Application by Net Zero Teesside Power Limited and Net Zero North Sea Storage Limited for an Order Granting Development Consent for the Net Zero Teesside Project

Please find enclosed a written representation submitted on behalf of EDF Energy Renewables Limited and Teesside Wind Farm Limited ("**EDF**") in respect of the above application.

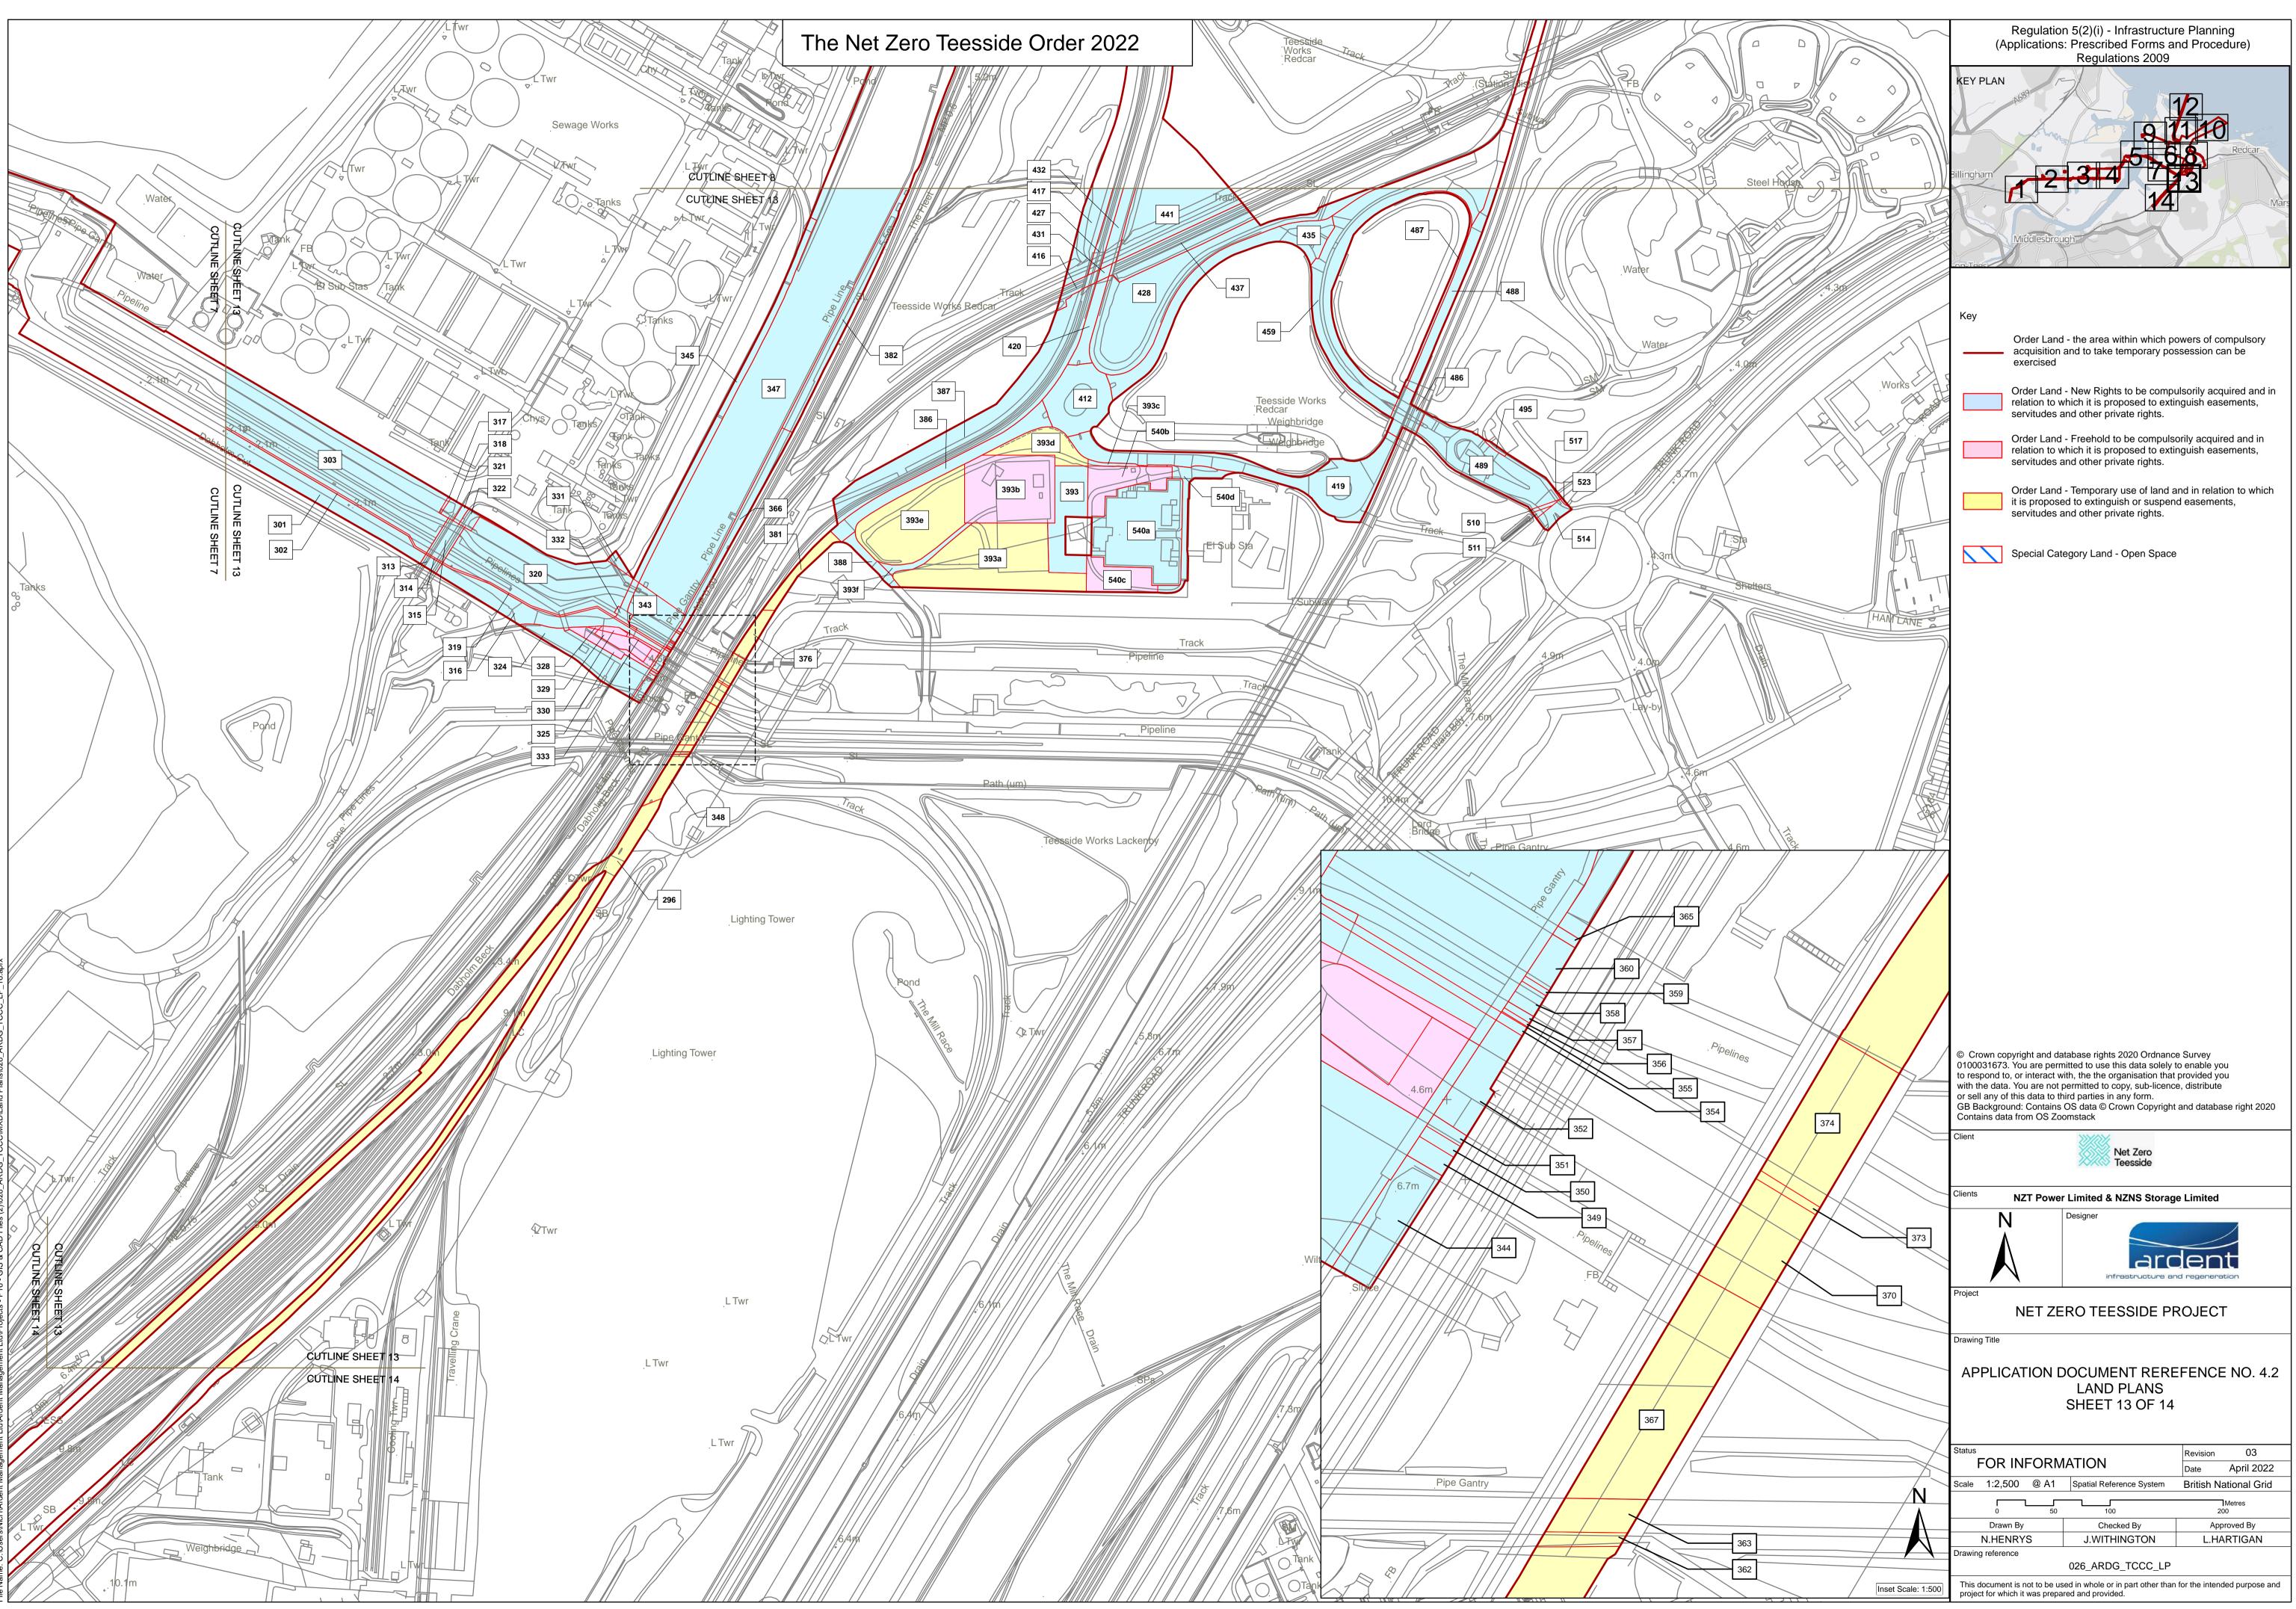
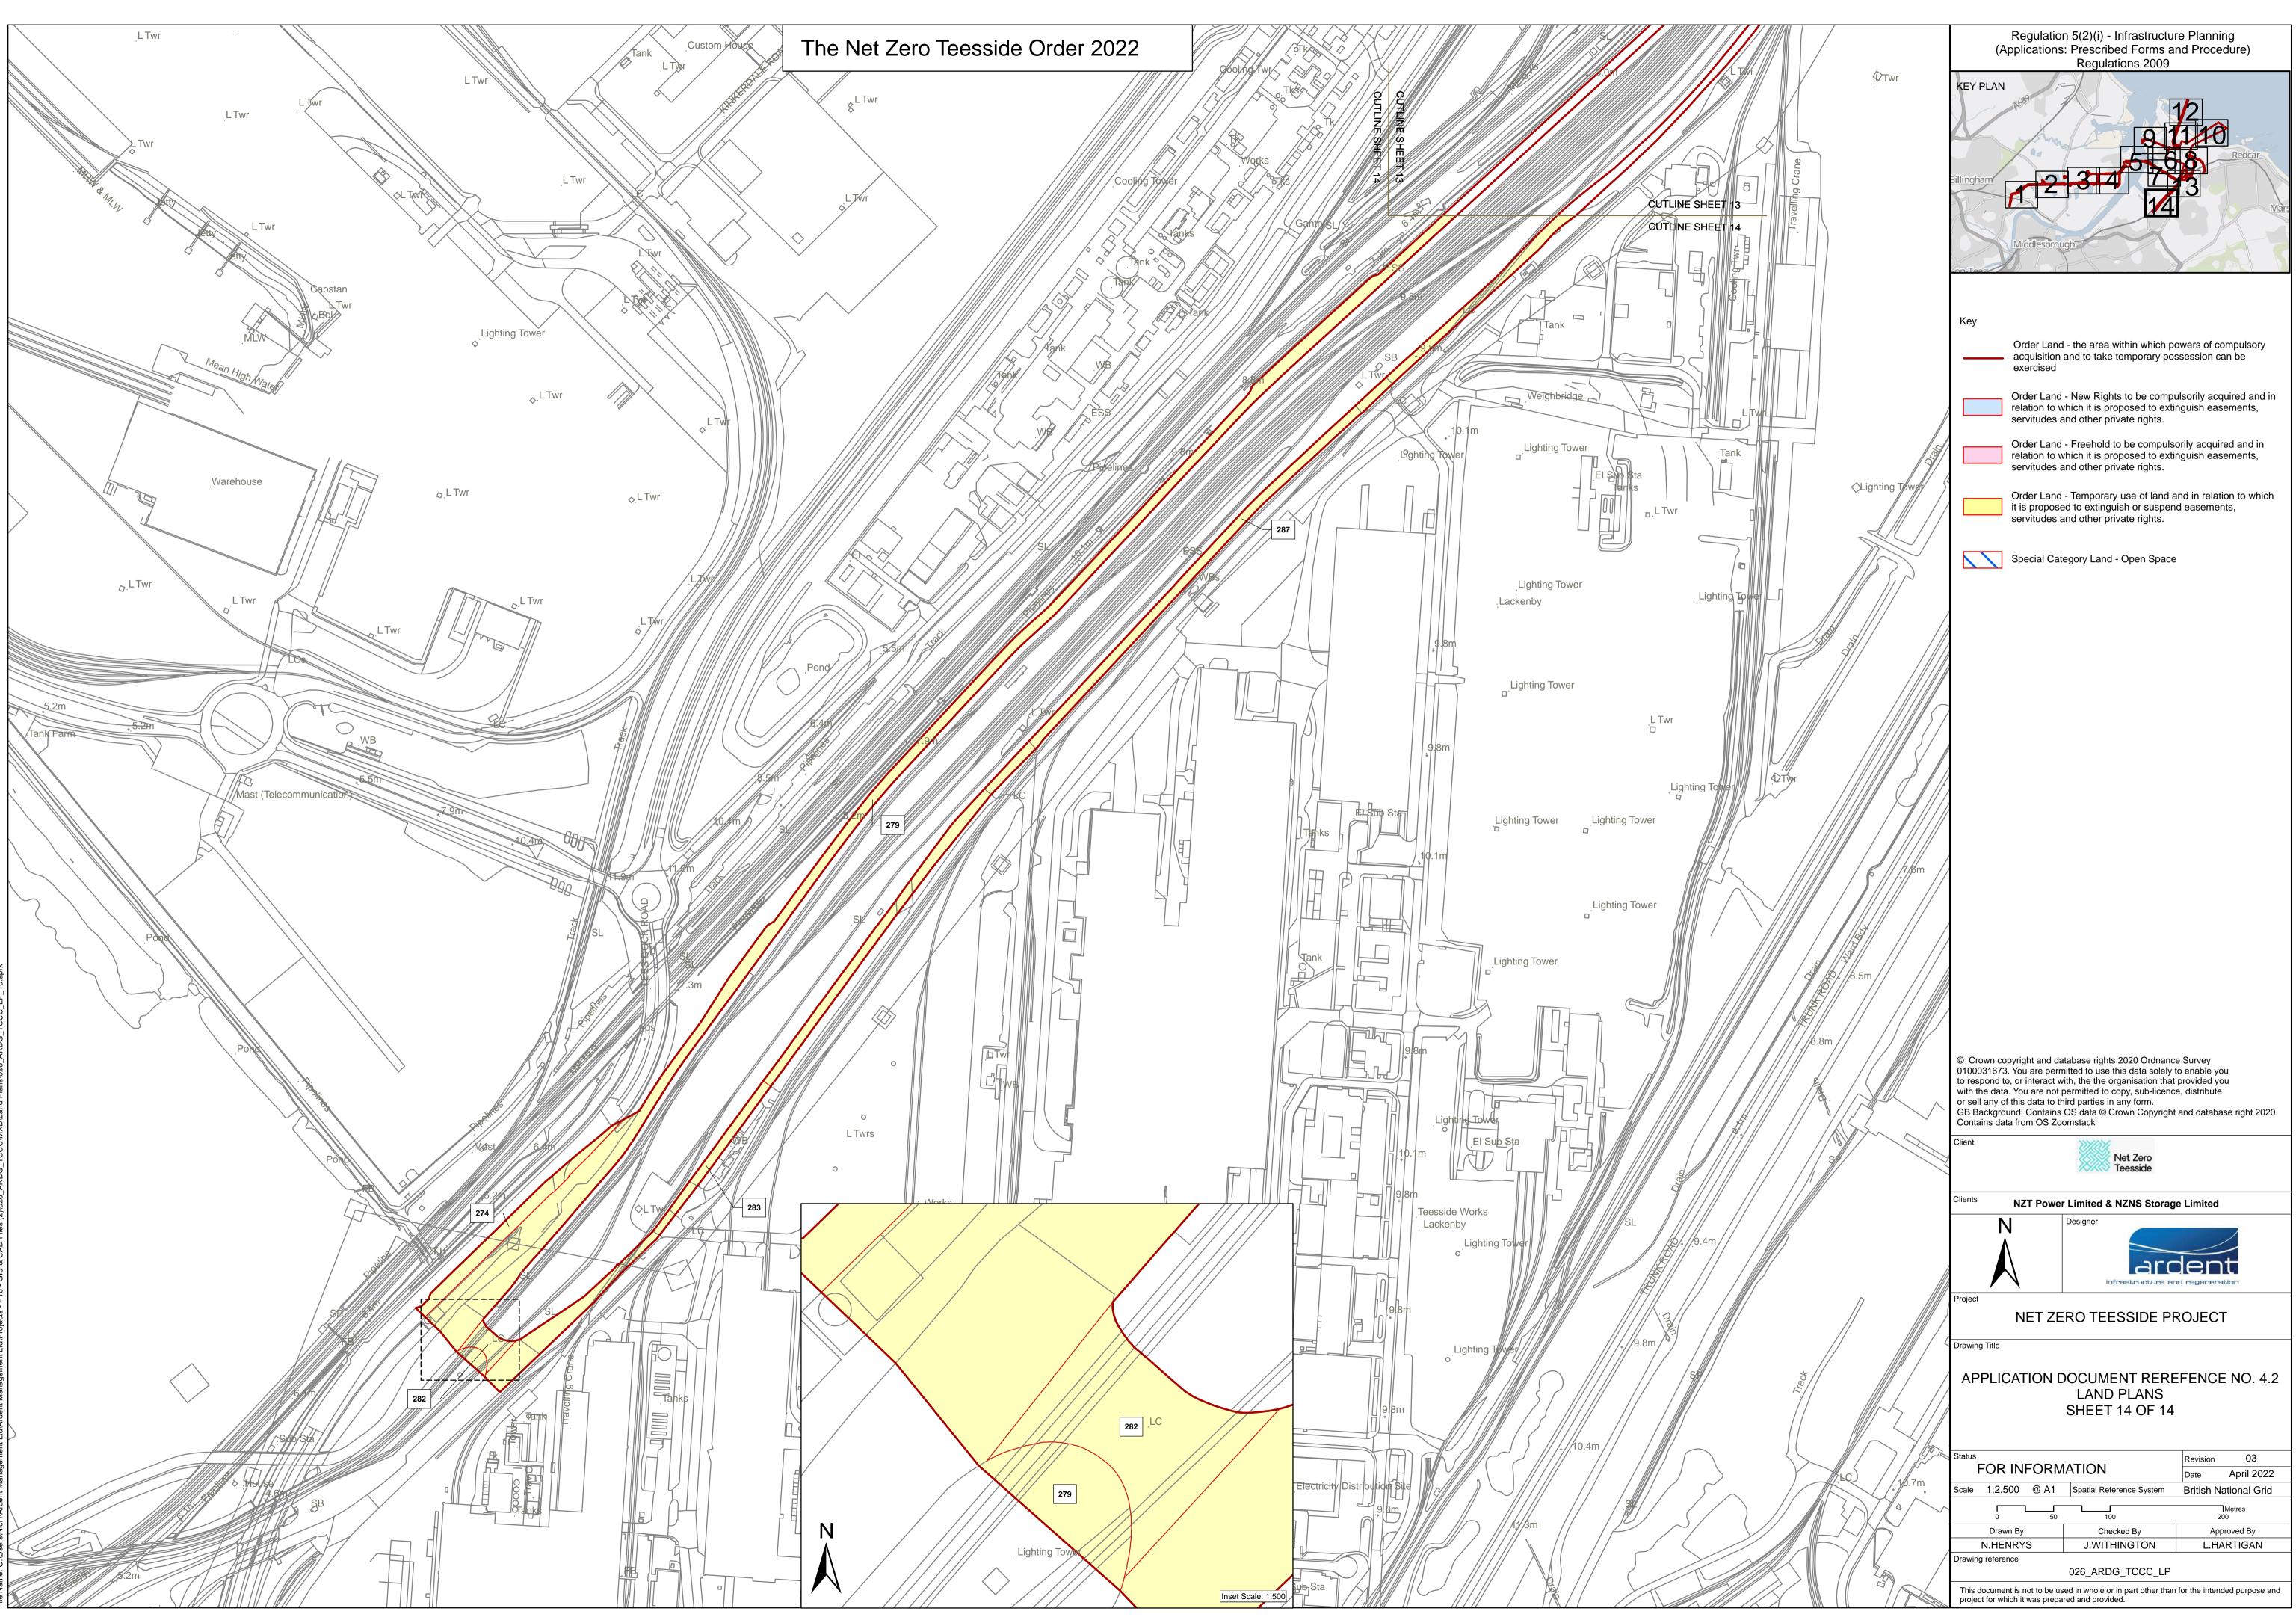
- Work No. 5 – wastewater disposal works in connection with Work No. 1, comprising—
(a) Work No. 5A – repair and upgrade of the existing water discharge infrastructure to the Tees Bay; or (b) Work No. 5B – a new water discharge pipeline to the Tees Bay; and (c) Work No. 5C – up to two new wastewater pipelines between Bran Sands Wastewater Treatment Plant and Work No. 1.
- Work No. 8 – high pressure carbon dioxide export pipeline corridor, comprising an overground and underground pipeline of up to 800 millimetres nominal bore diameter and associated power and fibre-optic cables.

These Works are shown on Sheets 10 and 12 of the Land Plans.

As a result of those discussions, EDF is concerned that the above Works may cause the following issues for the operation of Teesside Wind Farm:

1. Risks associated with vessels in close proximity to EDFs offshore turbines (during construction or maintenance).
2. The risk of any explorations or construction works damaging EDF's offshore cable connection, in particular but not limited to any bore holes that may be drilled in close proximity to EDF's offshore electricity connection.
3. Impacts associated with changes to the seabed that may impact upon the foundations of the offshore turbines.
4. Seismic effects that may result from the proposed works that may impact upon the stability of the offshore turbines foundations.

EDF are seeking to arrange an urgent meeting with the Applicant regarding protective provisions within the draft Development Consent Order to address the above matters, on which it is hoped that a conclusion will be reached shortly. To the extent agreement cannot be reached, EDF will maintain its objection to the draft Development Consent Order in relation to these matters.
